CITY OF ALBUQUERQUE

September 6, 2018

**Re: Campo Del Norte
Erosion and Sediment Control Plan
Engineer's Stamp Date 8-20-18 (C18E102)**

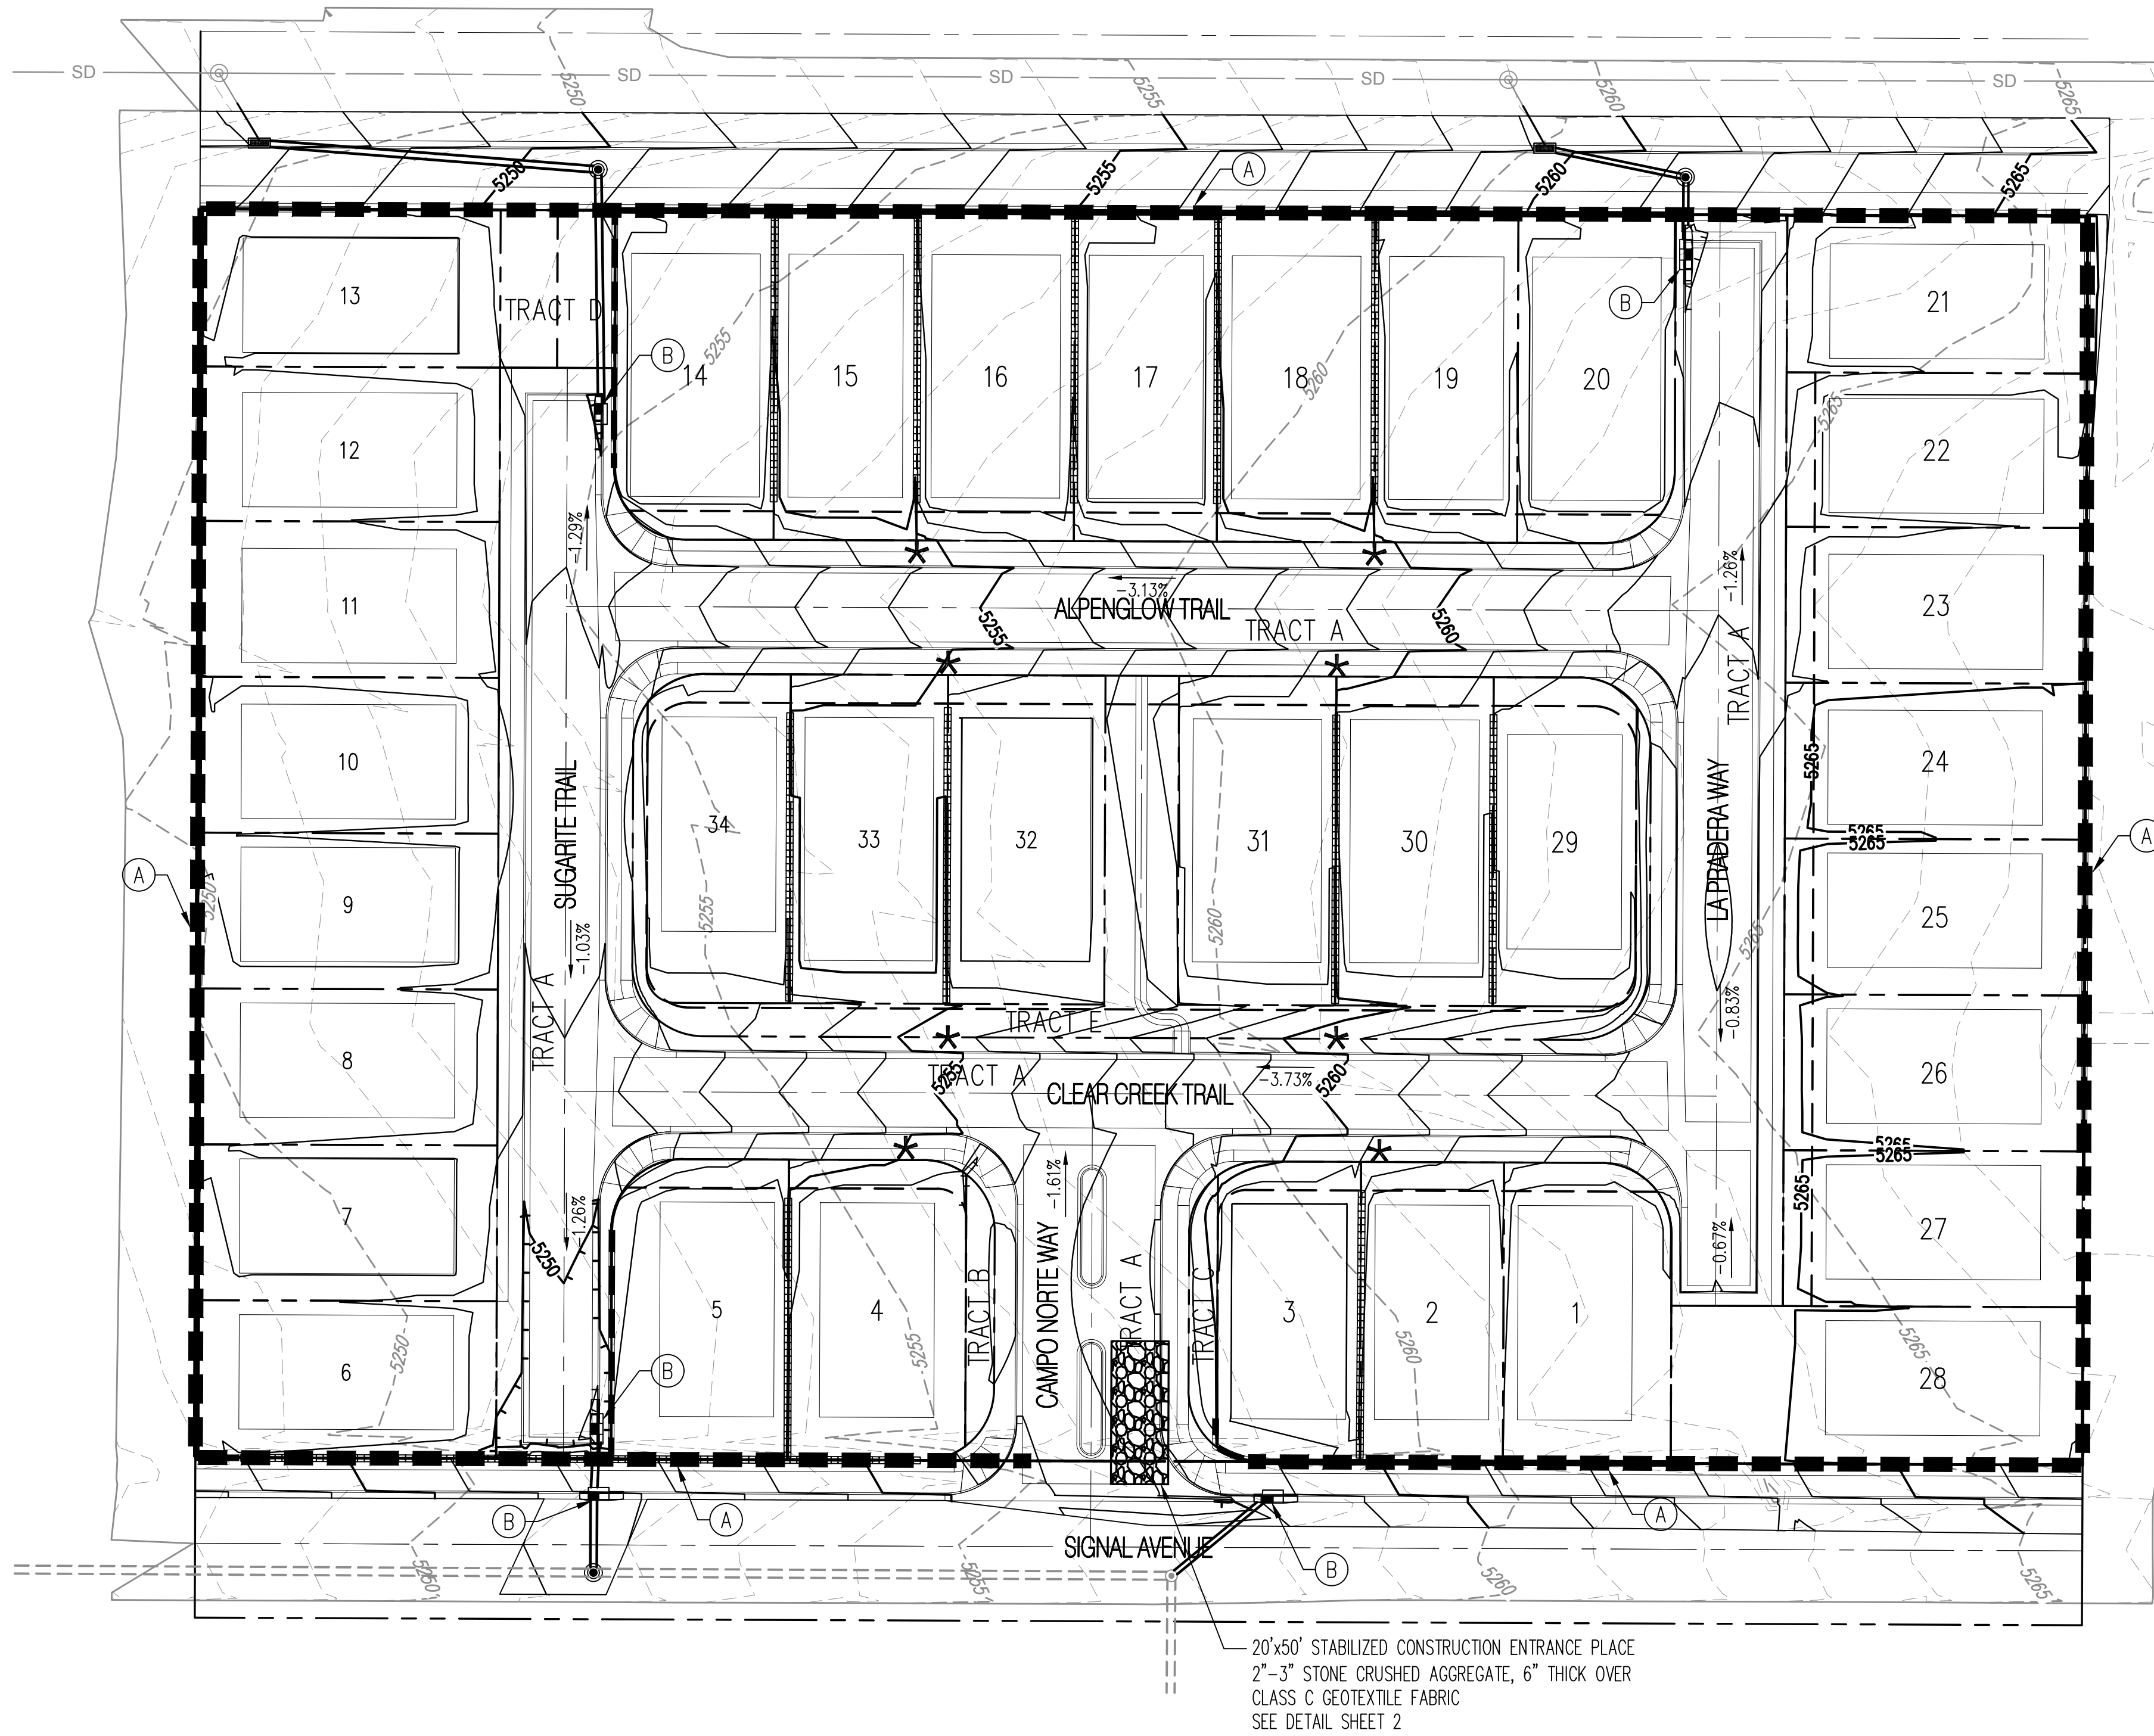
1. A sediment BMP (filter sock or similar) should be placed at the downstream end of the street work in Alameda Blvd and Signal Ave.

CUT BACK CURB DETAIL
NOT TO SCALE

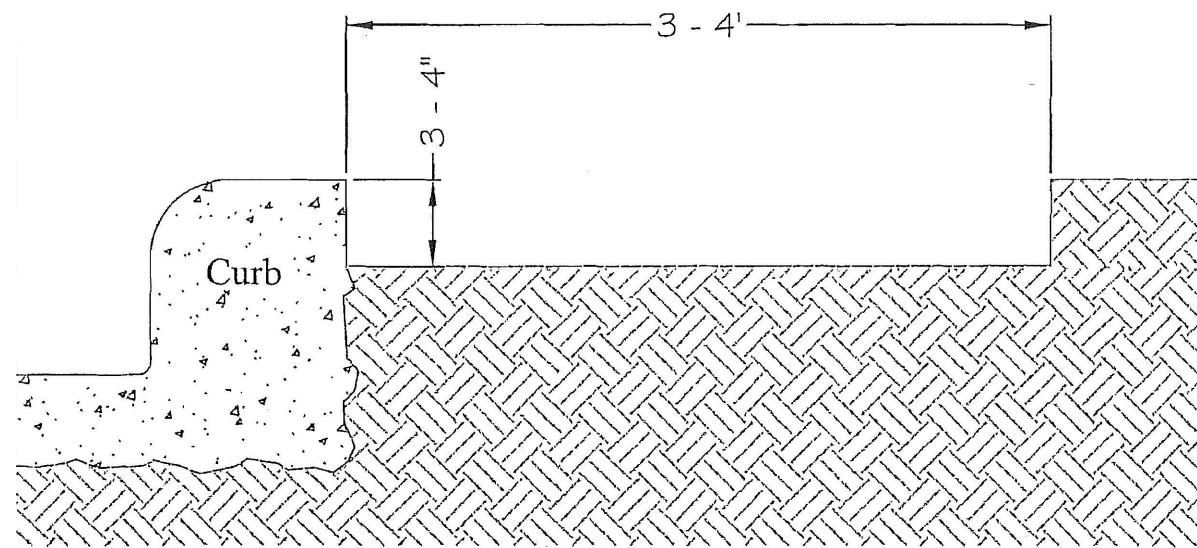
2. The Cutback curb detail is not deep or wide enough. A detail showing approximate acceptable dimensions is included with this letter.
